# CITY OF ALBUQUERQUE

**Re:** Sandia Foundation  
**807 Arno St NE**  
**Traffic Circulation Layout**  
Engineer's/Architect's Stamp XX-XX-XX (J14D181)

Based upon the information provided in your submittal received XX-XX-16, the above referenced plan cannot be approved for Building Permit until the following comments are addressed:

TRACT 2-A (1.3642 AC.)
 LANDS OF SANDIA FOUNDATION
 807 ARNO ST., NE. ABOQ NM 87102
 TRAFFIC CIRCULATION LAYOUT
 GRADING / DRAINAGE

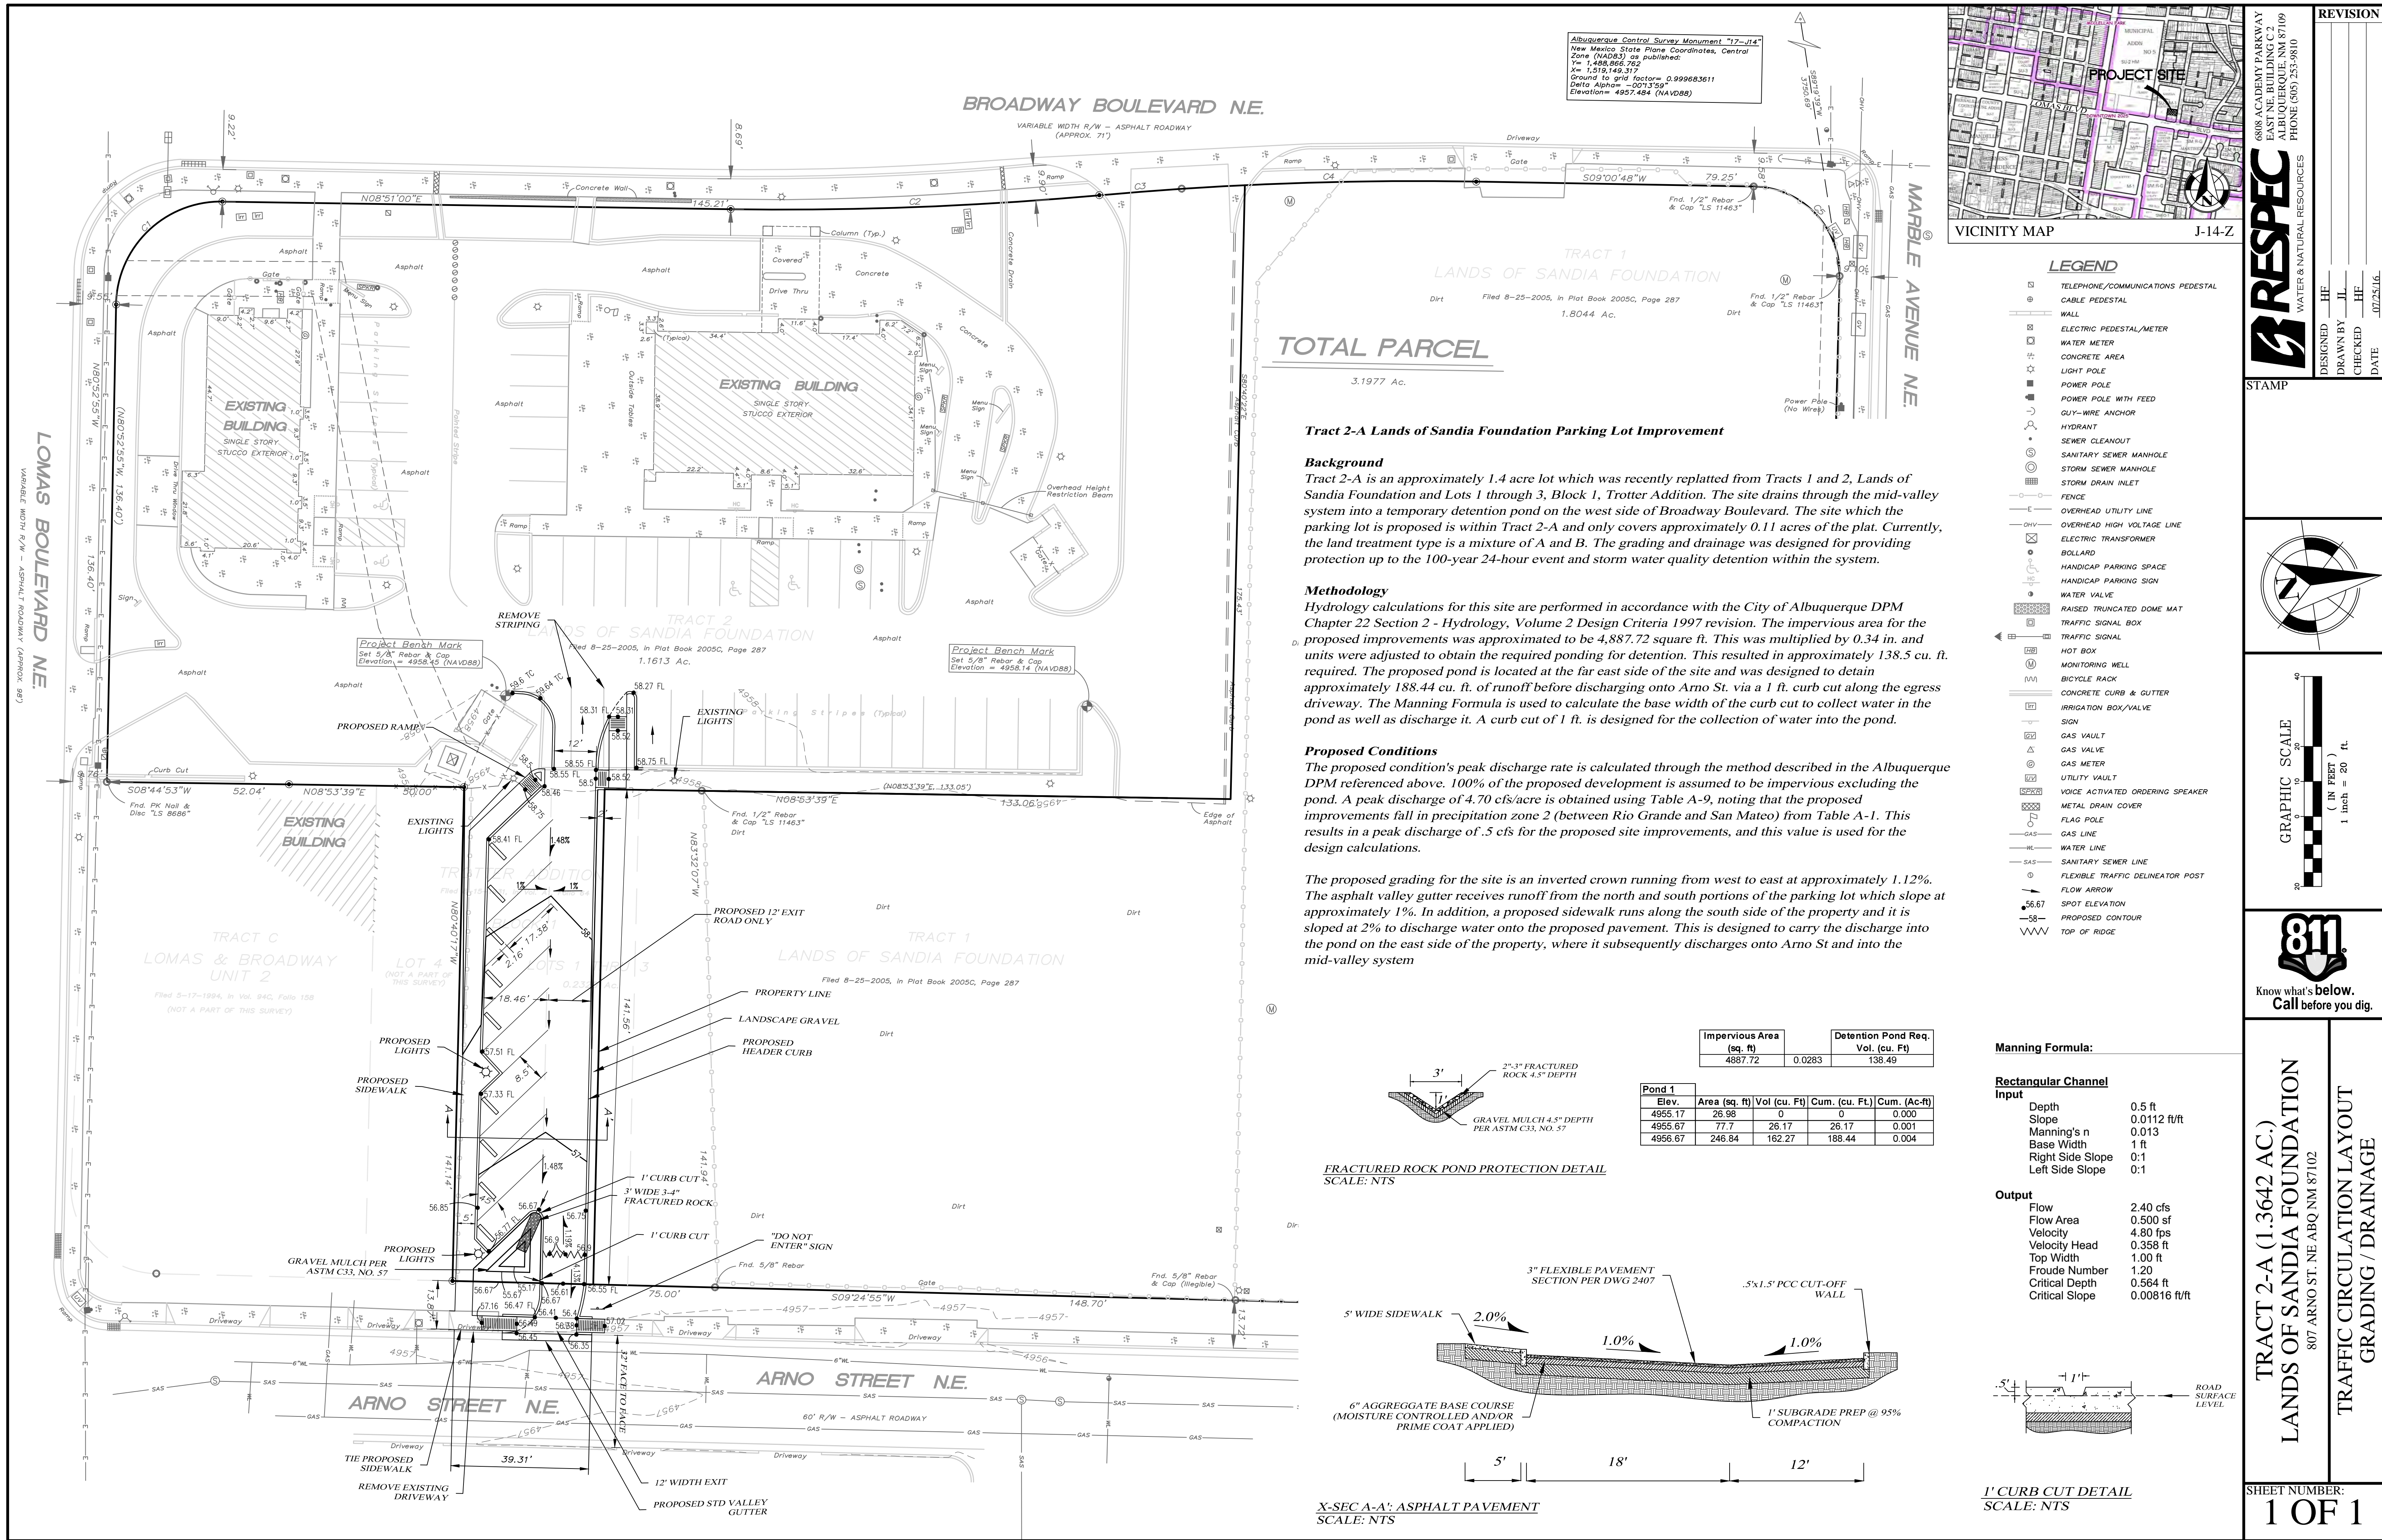
1. Show all drive aisle widths and radii of end islands
2. One-way vehicular paths require pavement directional signage and a posted **"Do Not Enter"** sign at the point of egress. Please show detail and location of posted signs.
3. Please specify the City Standard Drawing Number when applicable.
4. Unused curb cuts must be replaced with sidewalk and curb & gutter. A build note must be provided referring to the appropriate City Standard drawing.
5. A gutter at the East drive way is not necessary unless required by Hydrology.
6. Please include two copies of the traffic circulation layout at the next submittal.

- ✓ 1. Show all drive aisle widths and radii of end islands.
  - 12' drive aisle width is in plan at the entrance of parking lot and mid parking lot.
- ✓ 2. One way vehicular paths require pavement directional signage and a posted "Do Not Enter" sign at the point of egress. Please show detail and location of posted signs.

- "Do Not Enter" sign location is at the egress of lot and a detail has been added to the plan.
- ✓ 3. Please specify the City Standard Drawing Number when applicable.

- Drawing numbers have been added to plans where necessary.
- ✓ 4. Unused curb cuts must be replaced with sidewalk and curb & gutter. A build note must be provided referring to the appropriate City Standard drawing.

- Callout details near the driveway at the west side of the lot have been cleaned up. The callouts now show where the proposed sidewalk ties to existing and to remove the driveway and replace with sidewalk, curb, and gutter per standard drawings.

- ✓ 5. A gutter at the East drive way is not necessary unless required by Hydrology.
  - Proposed gutter removed, to be addressed after Hydrology review.
